UTS MEMO

SUBJECT: MP_09_0153-01- DR CHAU CHAK WING BUILDING- 75W APPLICATION- MARKED UP DRAWINGS

DATE: 22 JUNE 2012

A3-1.03

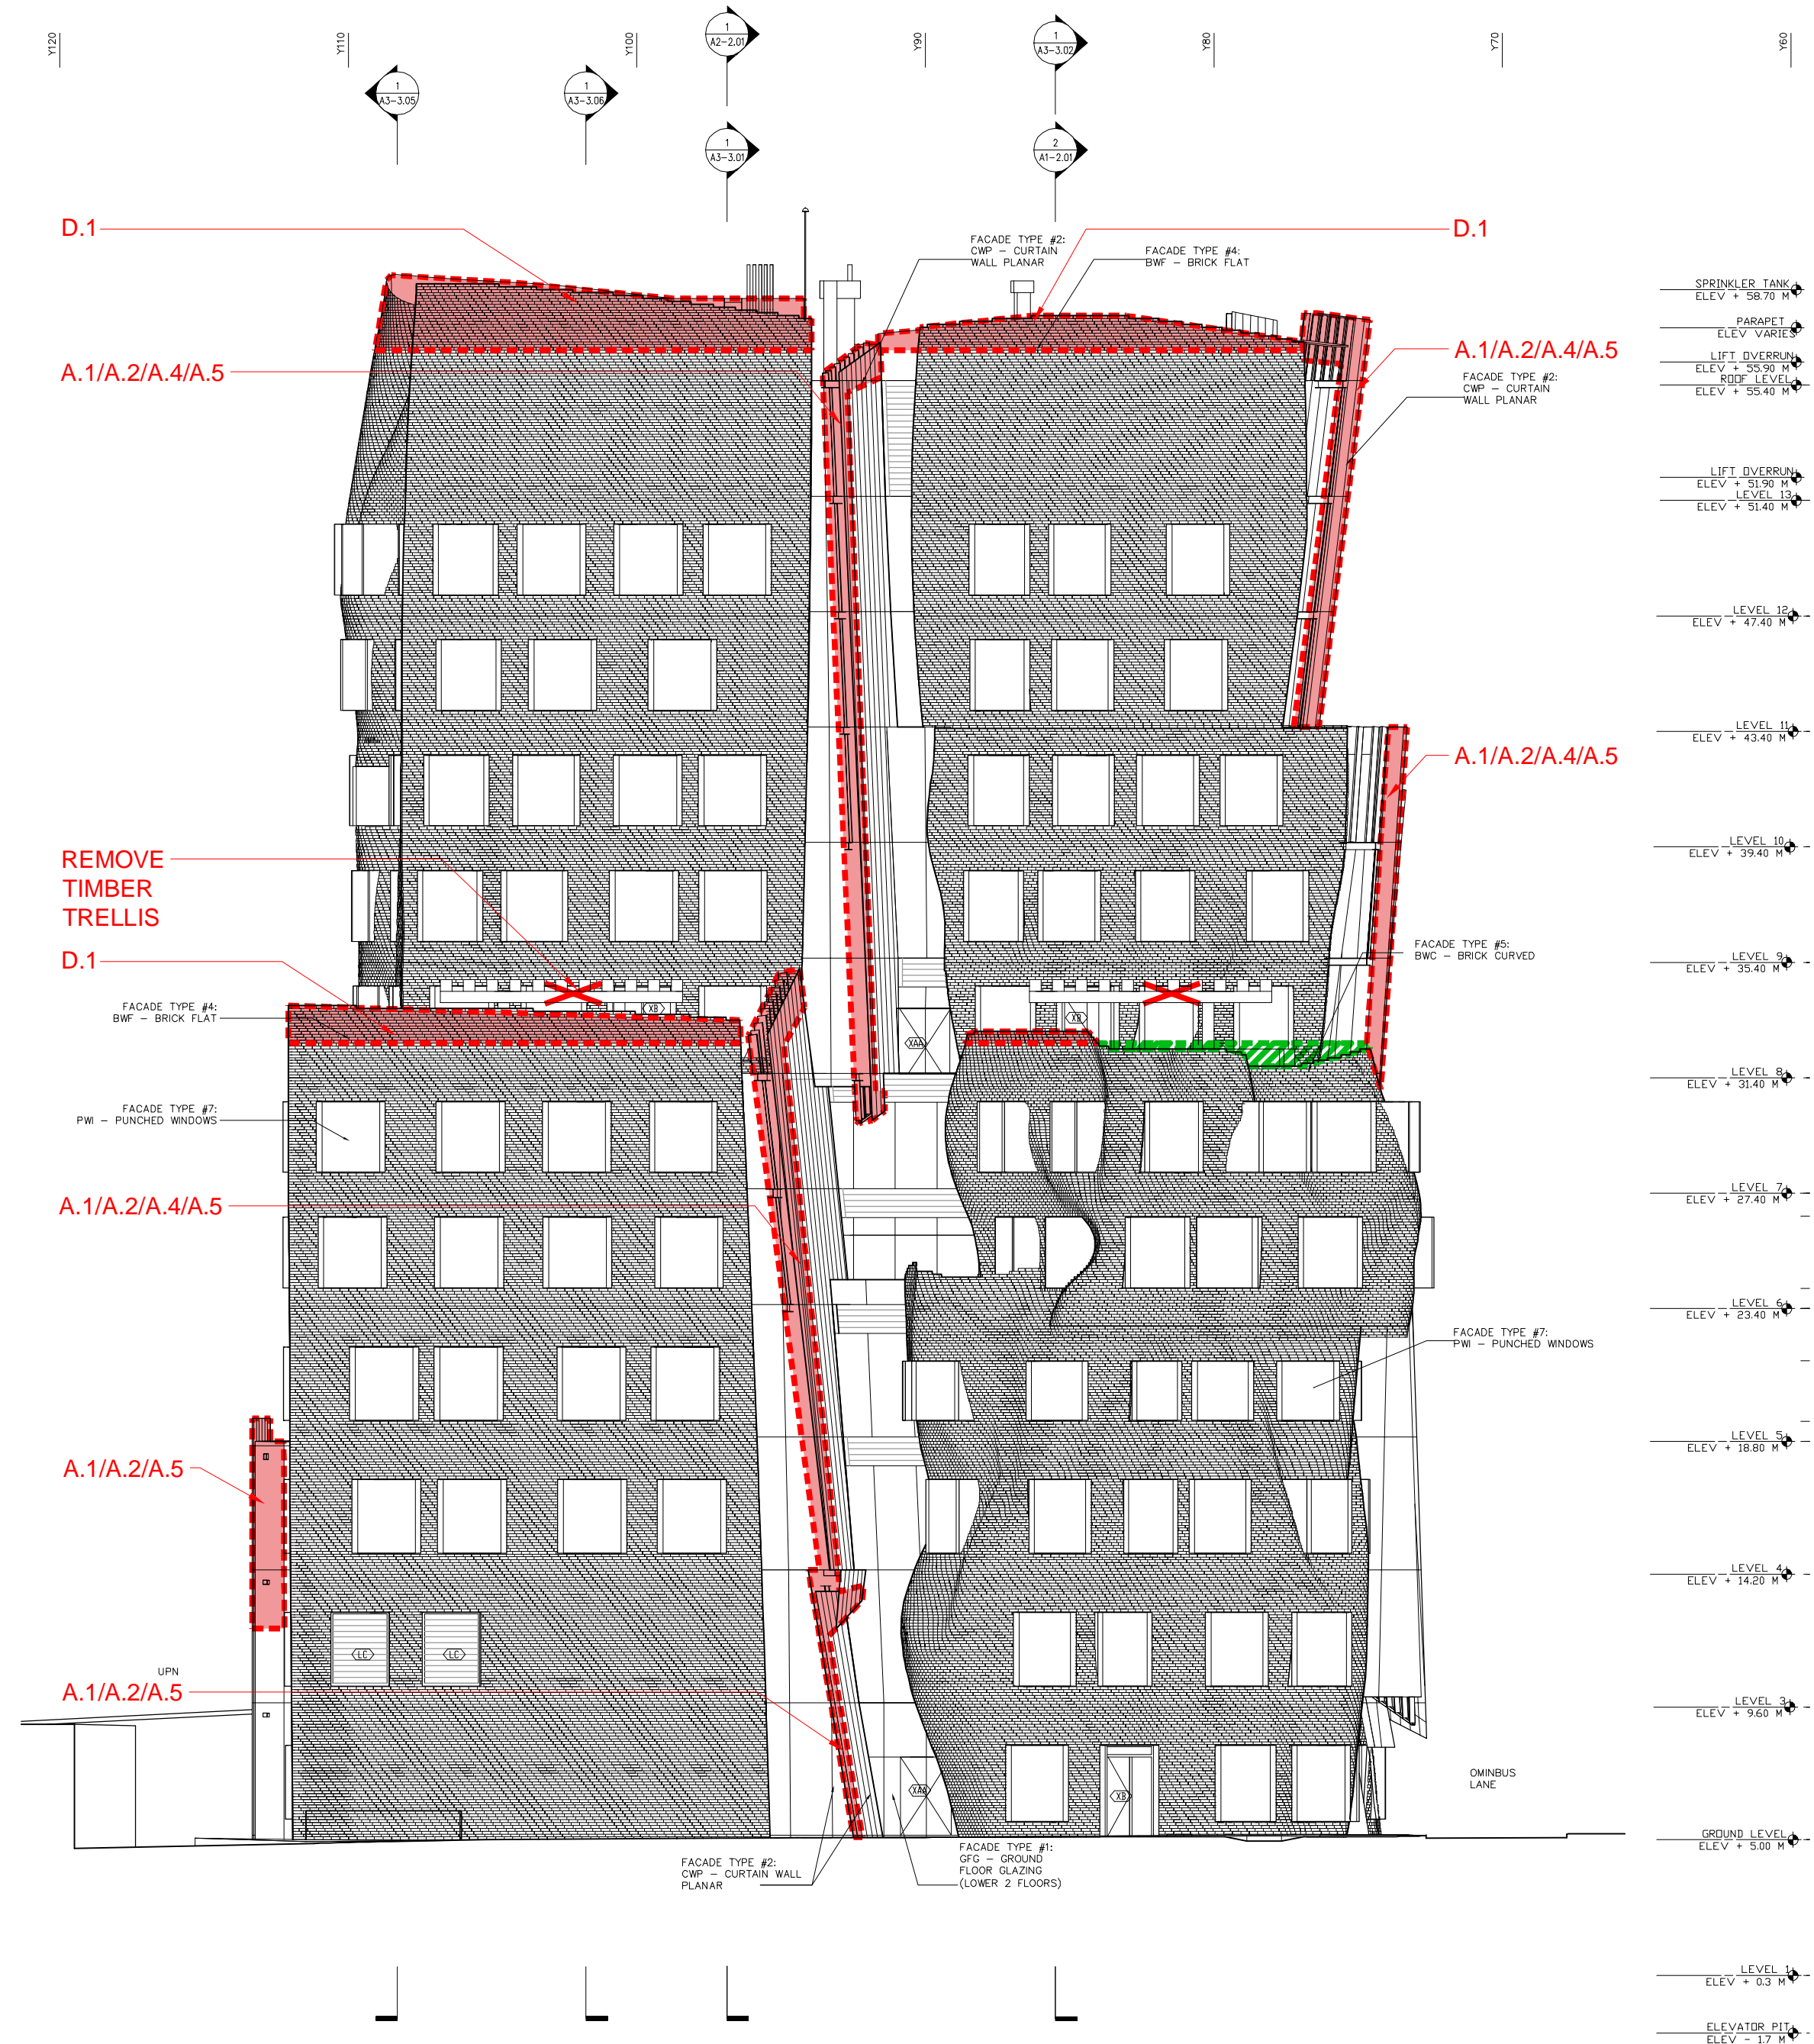
Attached is a set of marked up drawings high-lighting the changes to the facade between the March 4 2012 approved documents and the current design.

- Reduction in extent of glazed fly-bys
- Levelling of parapets to terraces and roof level
- Slight modifications to geometry of brick work on eastern façade to adopt buildability issues raised by subcontractor.
